## **Phase 2 – Catalyst, Bicester** **Technical Note – LLFA / CDC Drainage Response**

This technical note has been produced as an addendum to Application No: 22/03677/DISC relating to discharge of Condition 40 (SW Drainage). This condition has been partially discharged for Phase 1 which is now complete. Phase 2 (Units 5-9) is the next and final phase of development for this application. Please find below Bailey Johnson Hayes responses to consultee comments received to date.

Part Site Plan 1:500

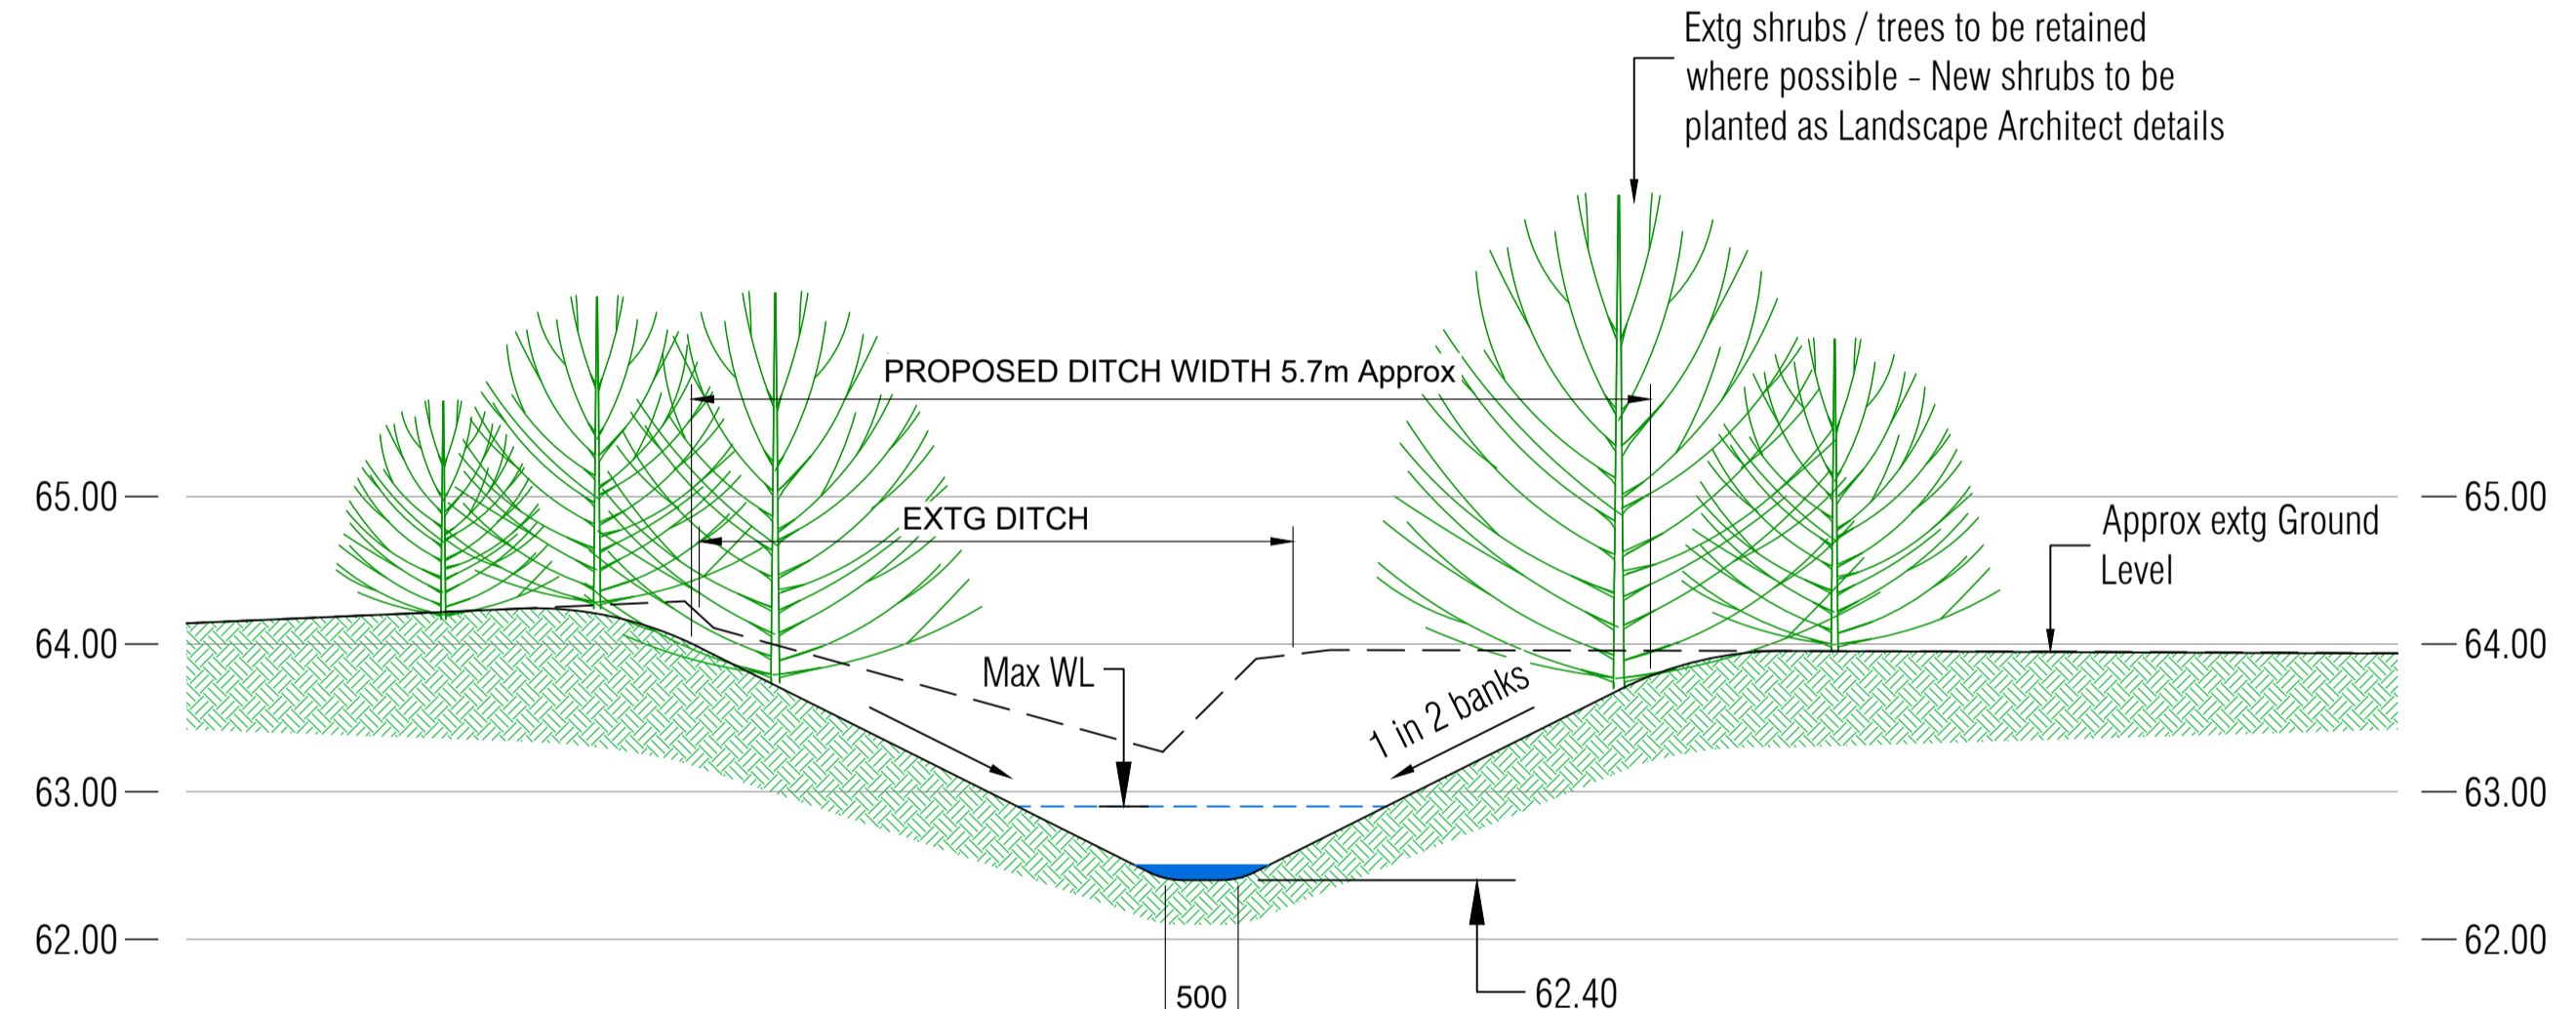
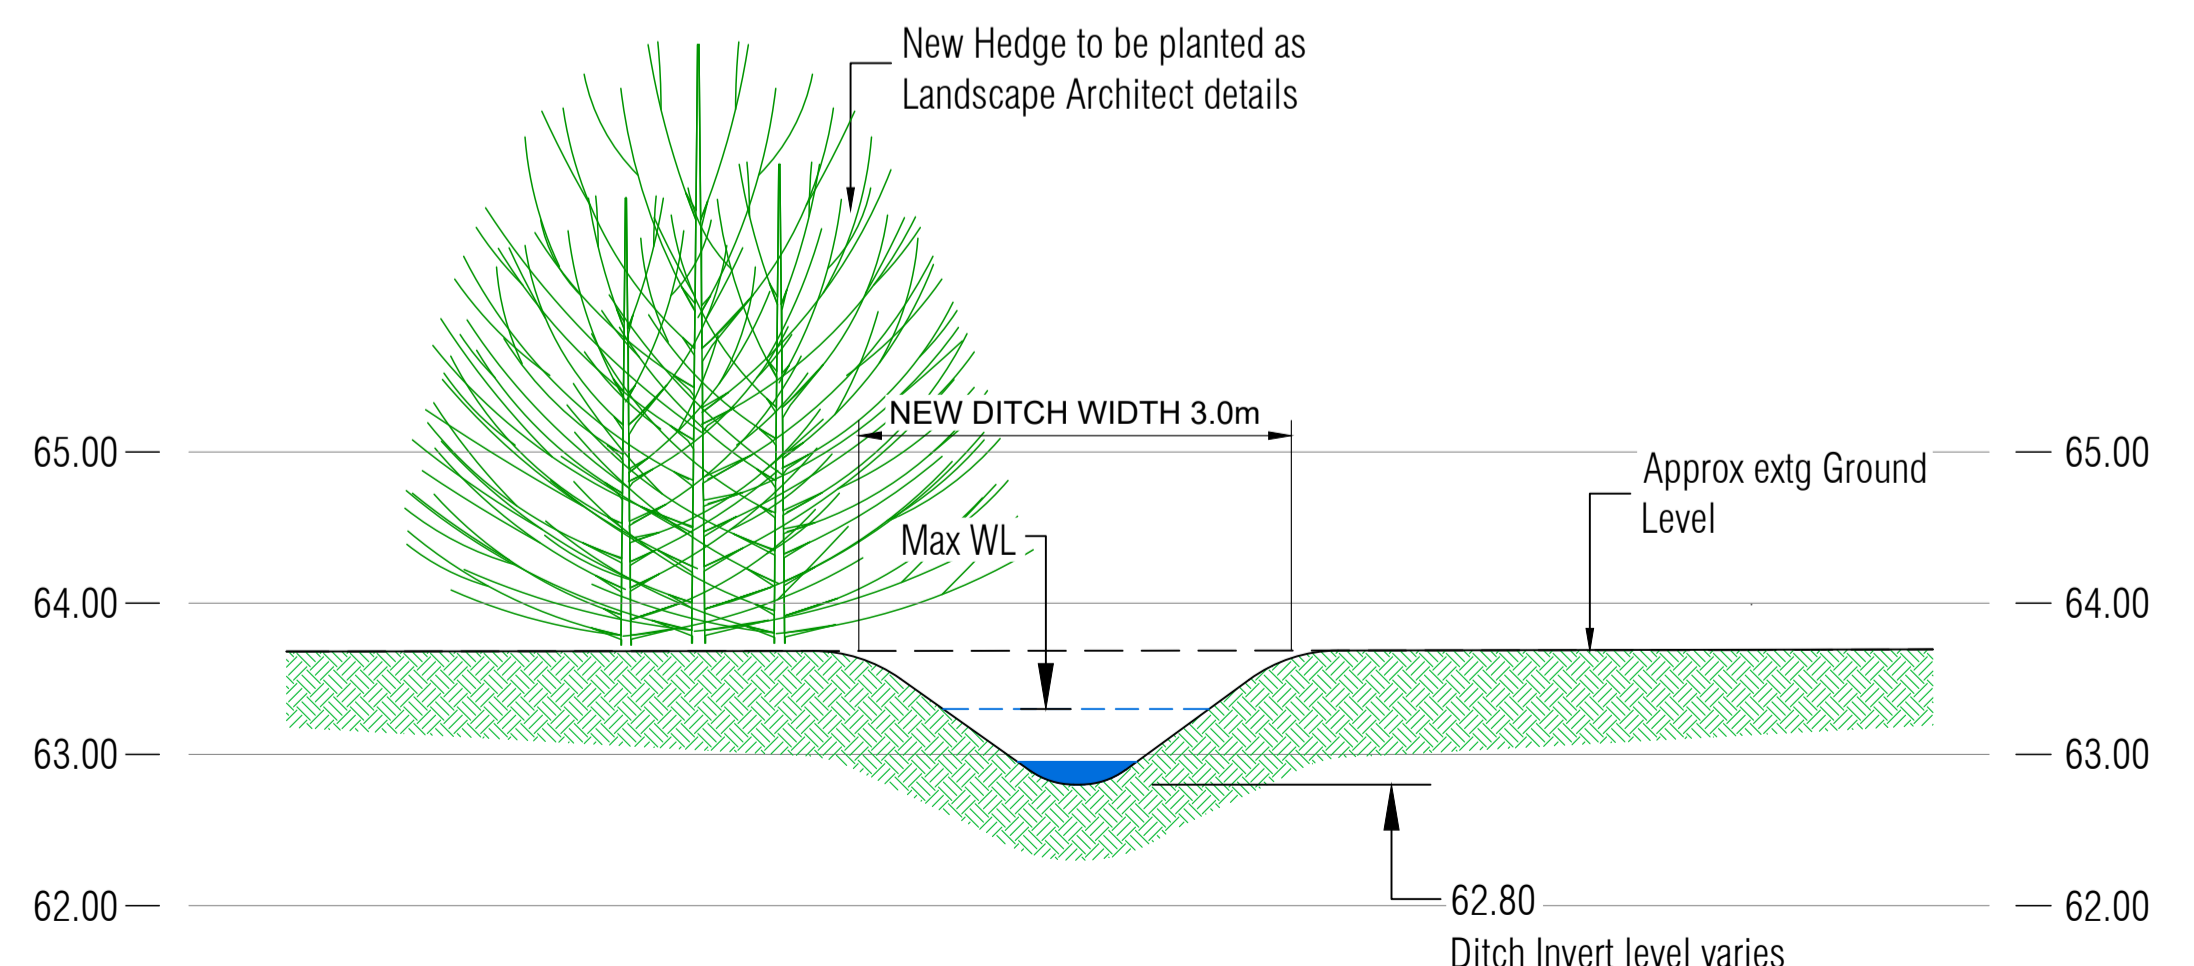
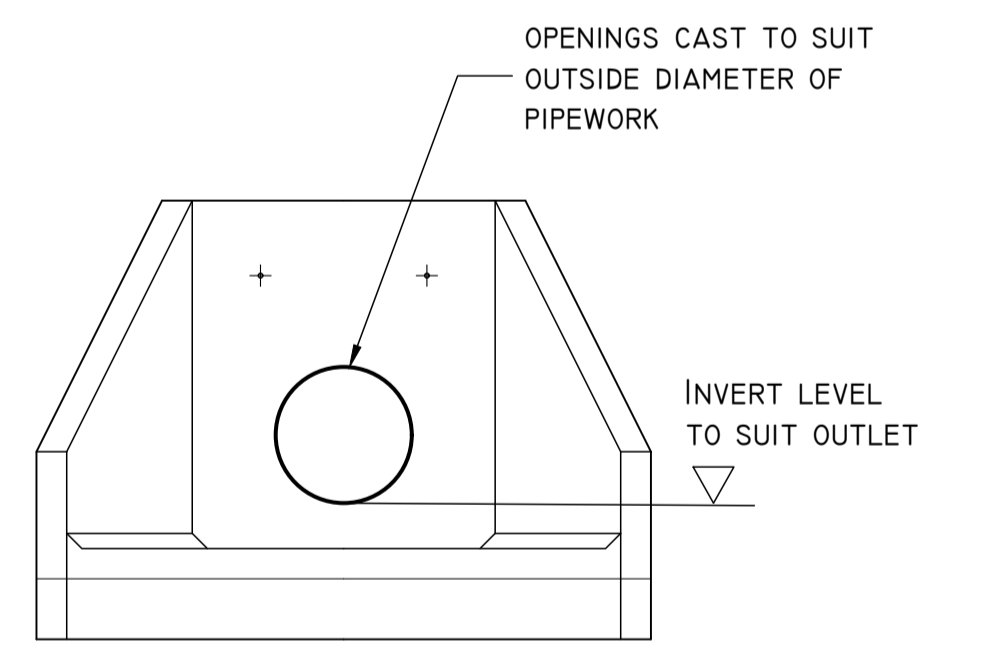
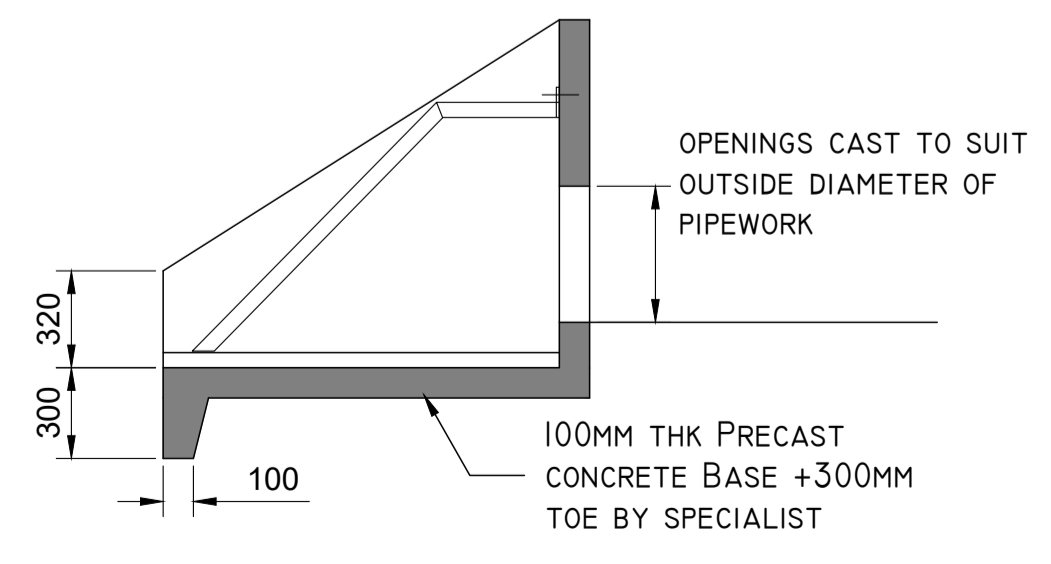
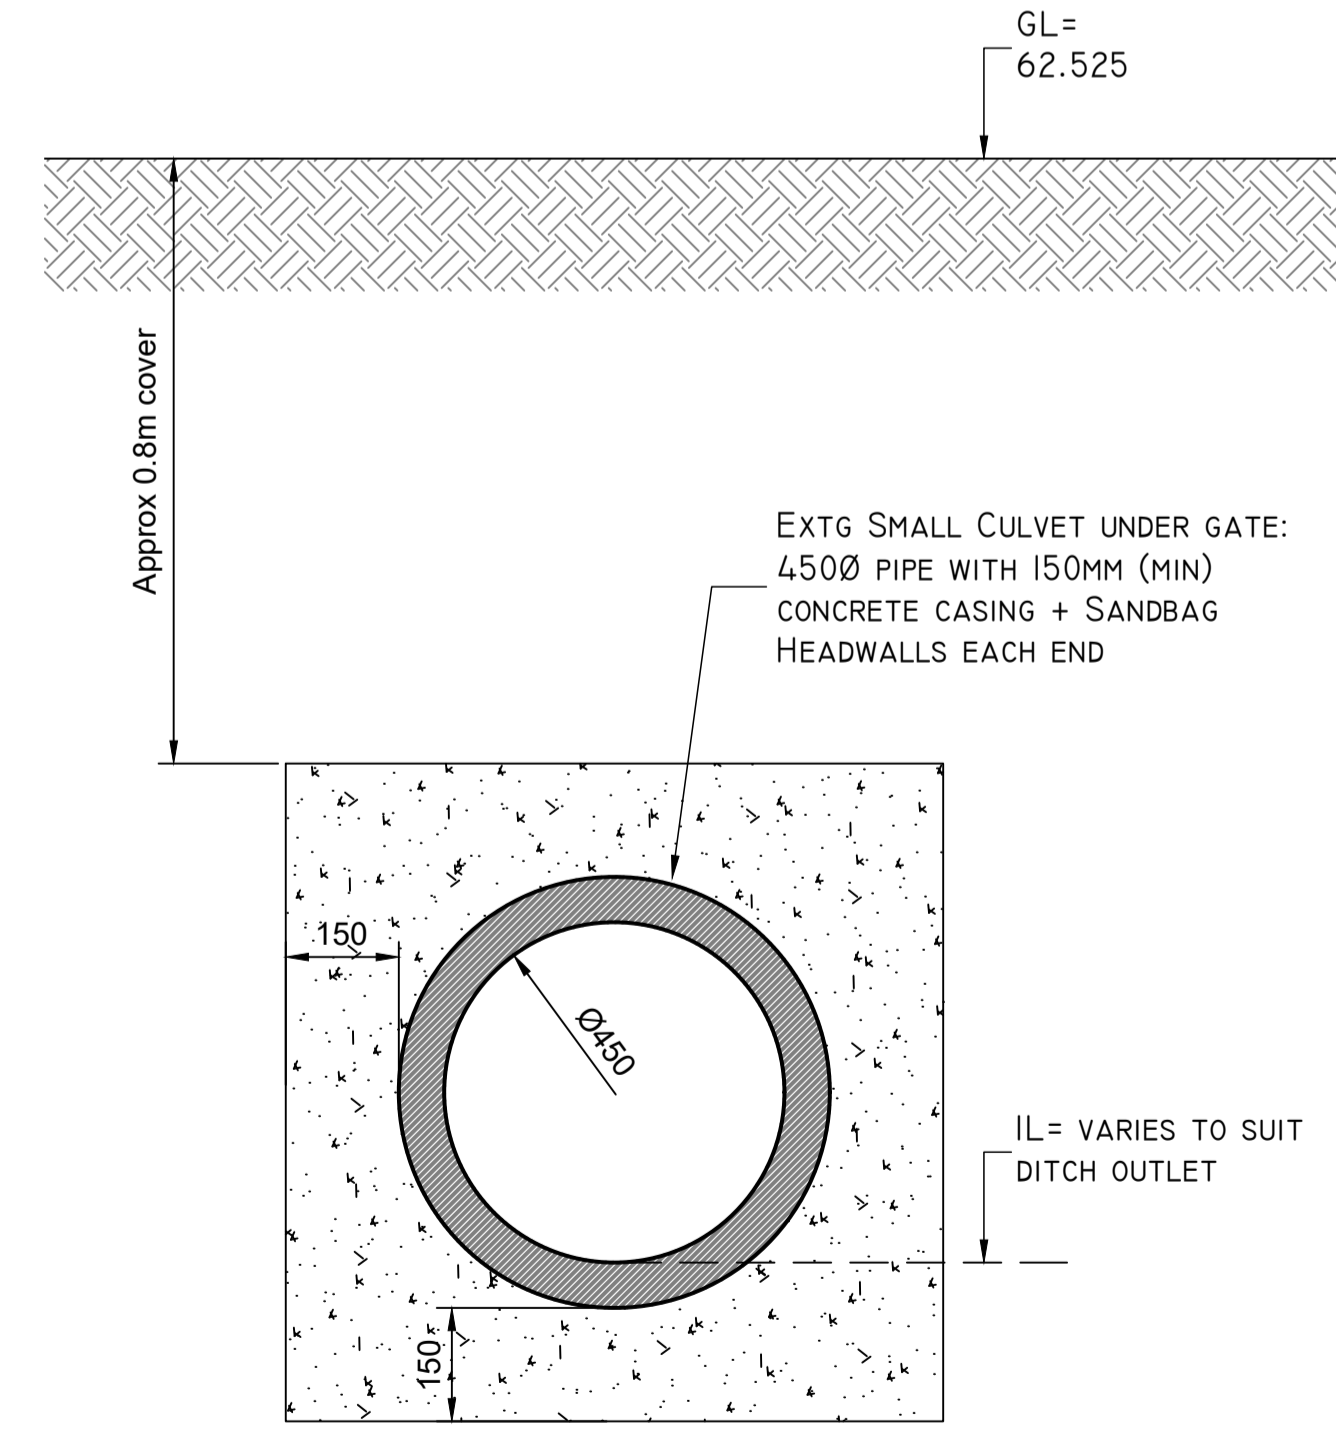
3. Provide consent to discharge to the existing watercourse.

1. I have not been able to inspect the outfall between the proposed attenuation basin and the receiving watercourse, the Langford Brook, due to the area being securely fenced at the time of visit. The outfall must be in sufficiently good condition to freely pass the outfall discharges and maintained thereafter. The discharge to the Langford Brook will require a consent from the environment Agency.

Application submitted to Tony Brummell at Cherwell District Council for approval of headwalls, culvert and re-graded outfall ditch to the Langford Brook.

Full details of outfall arrangements submitted to Cherwell District Council for approval of headwalls, culvert and re-graded outfall ditch to the Langford Brook.

Note:- No works proposed within 8m of River so EA approval not required.
